CLAREMONT BUSINESS PARK 2 FIL. NO. 1 - LOT 7

EL PASO COUNTY, STATE OF COLORADO GRADING & EROSION CONTROL PLAN

EPC STORMWATER REVIEW COMMENTS
IN ORANGE BOXES WITH BLACK TEXT

GRADING & EROSION CONTROL PLAN
CLAREMONT BUSINESS PARK 2 FIL. NO. 1 - LOT 7
JOB NO. 44-037
DATE PREPARED: AUG 31, 2020
DATE REVISED:

**CLAREMONT BUSINESS PARK 2 FIL. NO. 1  
LOT 7 SITE GRADING PLAN**

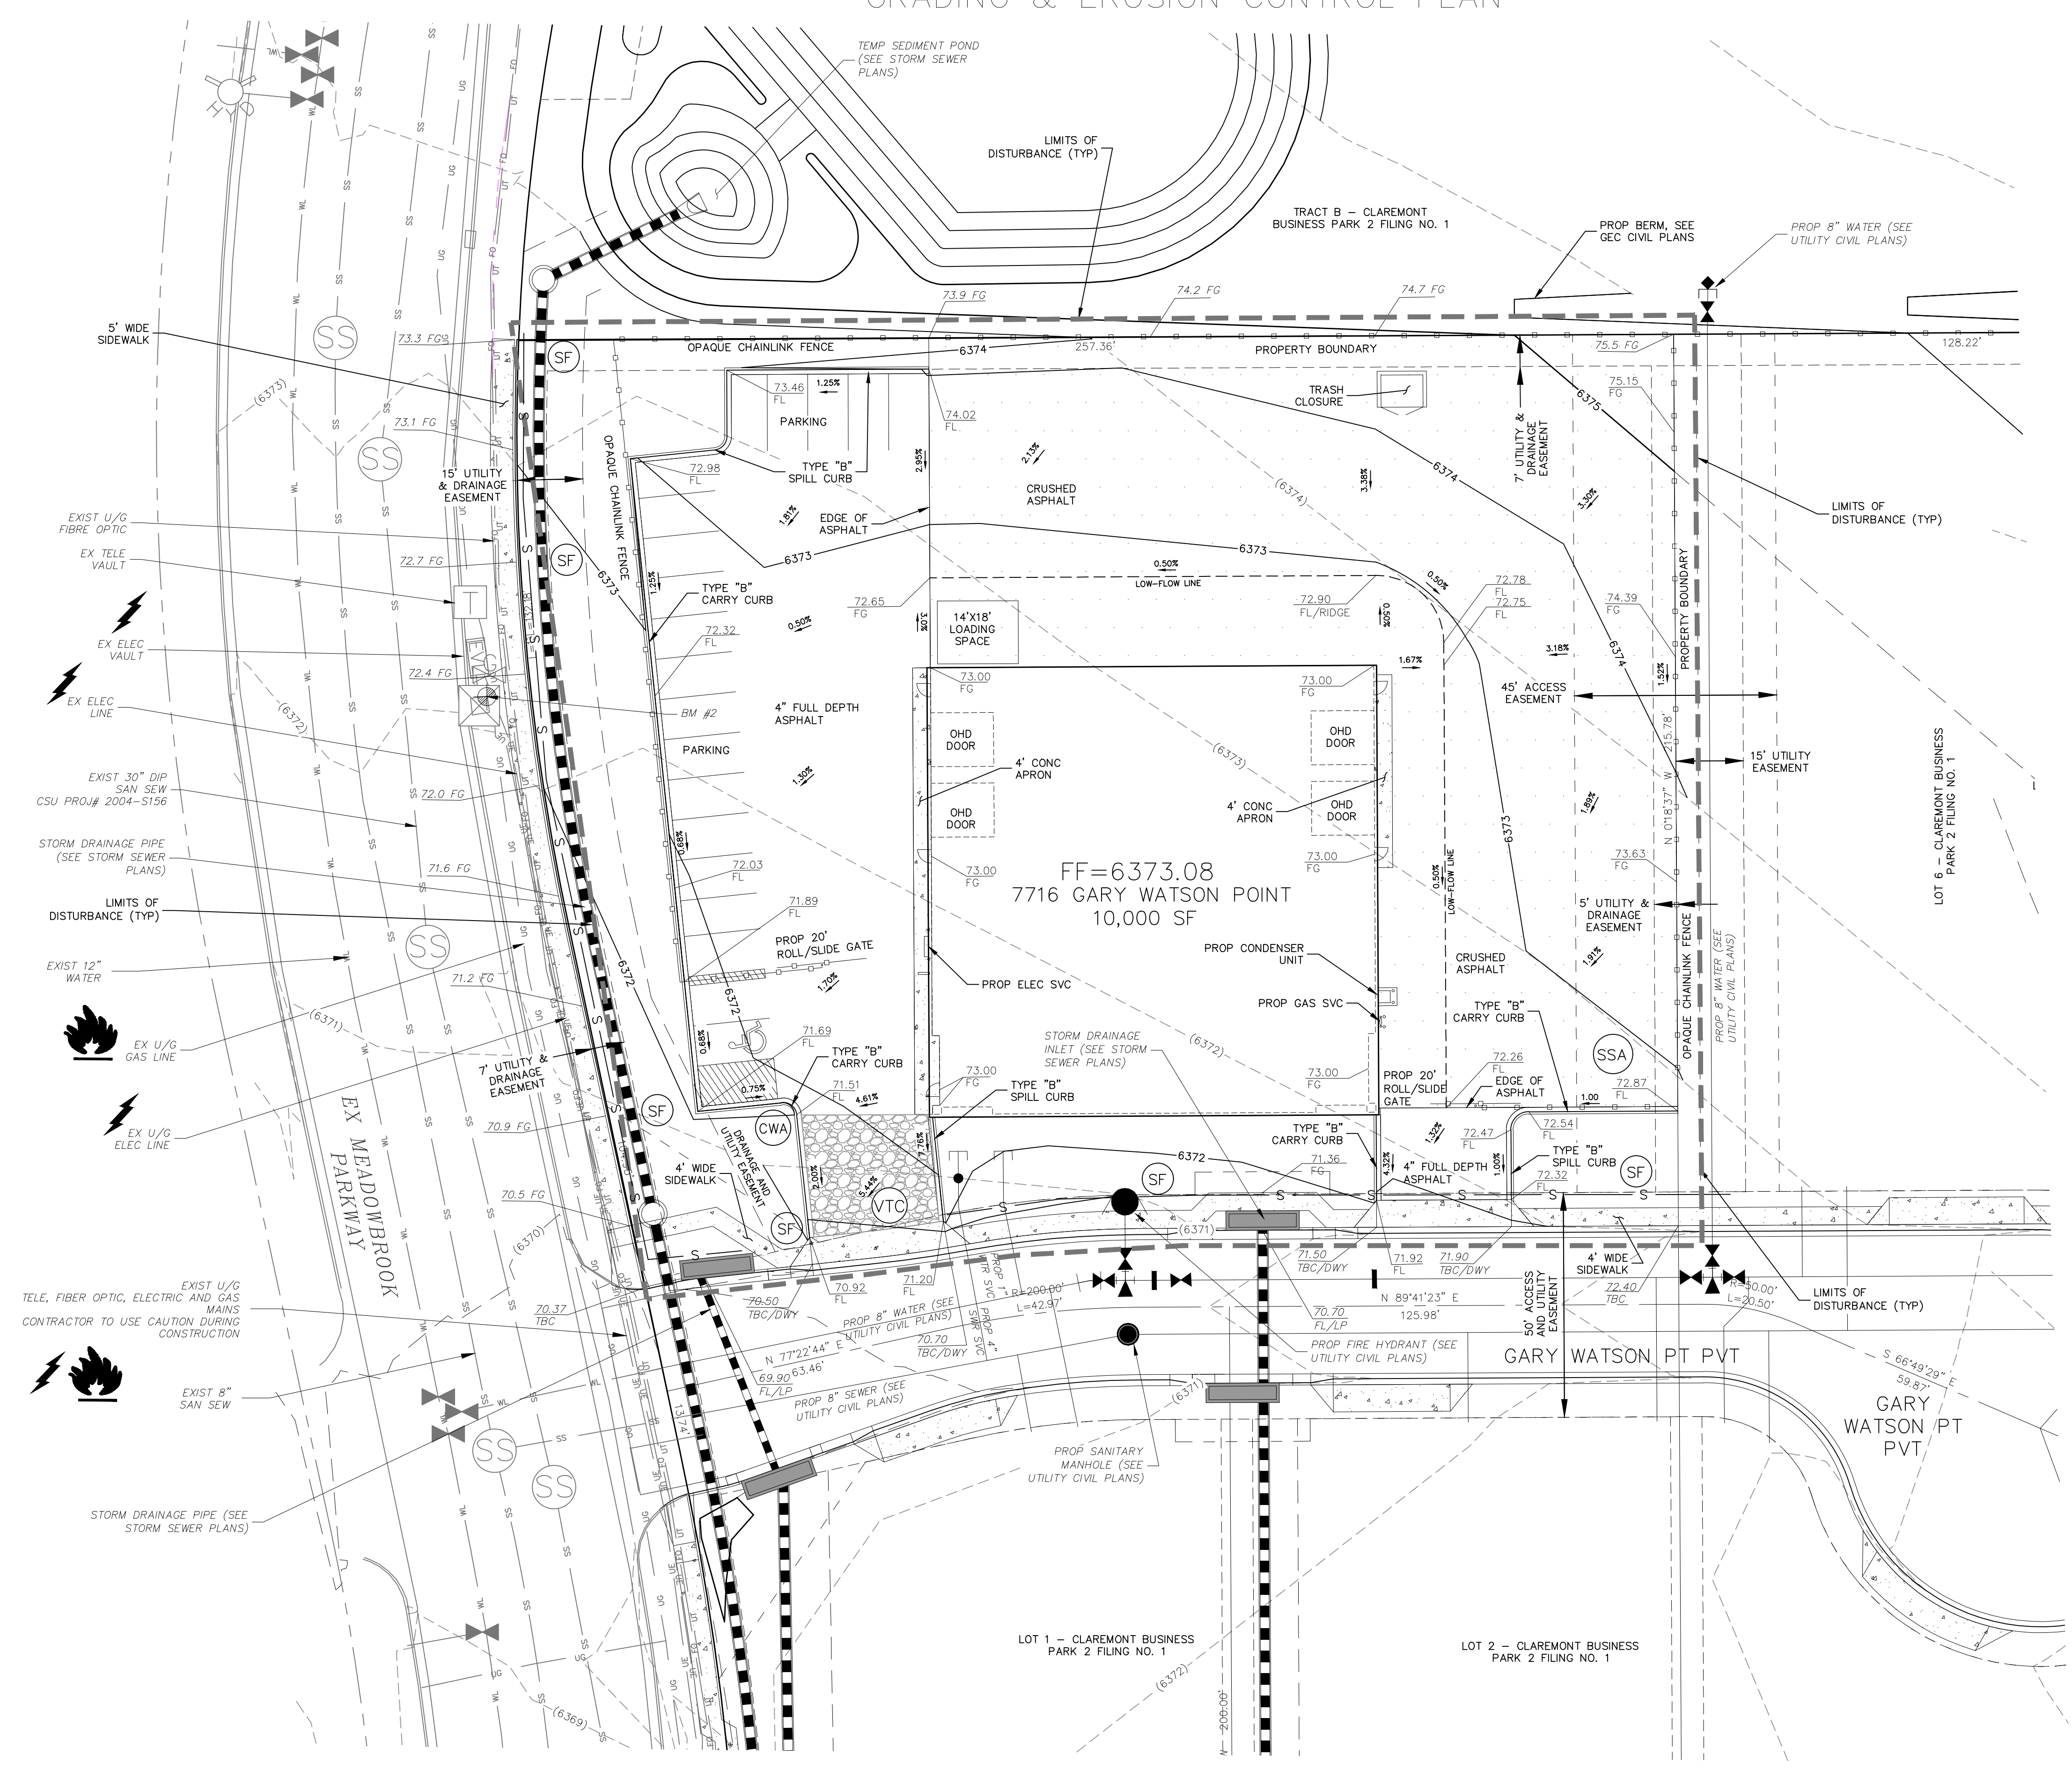
Item 1: include note about condition and type of existing vegetation

include details for CWA, Seeding/Mulching, SF, SSA, and VTC (w/ min 75ft length)

Install inlet protection (typ. 4'). Will IP be left in place from SF2014 - overall site grading and prep? Either way show it here as well but can label as existing so no one is confused and it doesn't get included in the FAE.

Minimum VTC length is 75ft per detail. Revise VTC on plan accordingly

Show temp barricades to keep vehicles from entering/exiting without going over VTC, or put VTC here, until paving is complete.

If same as Construction Boundaries, revise label to say: "Limits of Disturbance / Construction"

Add the following items to the Legend:
- Drainage flow arrows
- cut/fill line

Hatch areas to receive permanent seed/mulch and/or add a note stating the criteria for when/how/where seeding will be done (example: disturbed areas not being landscaped).
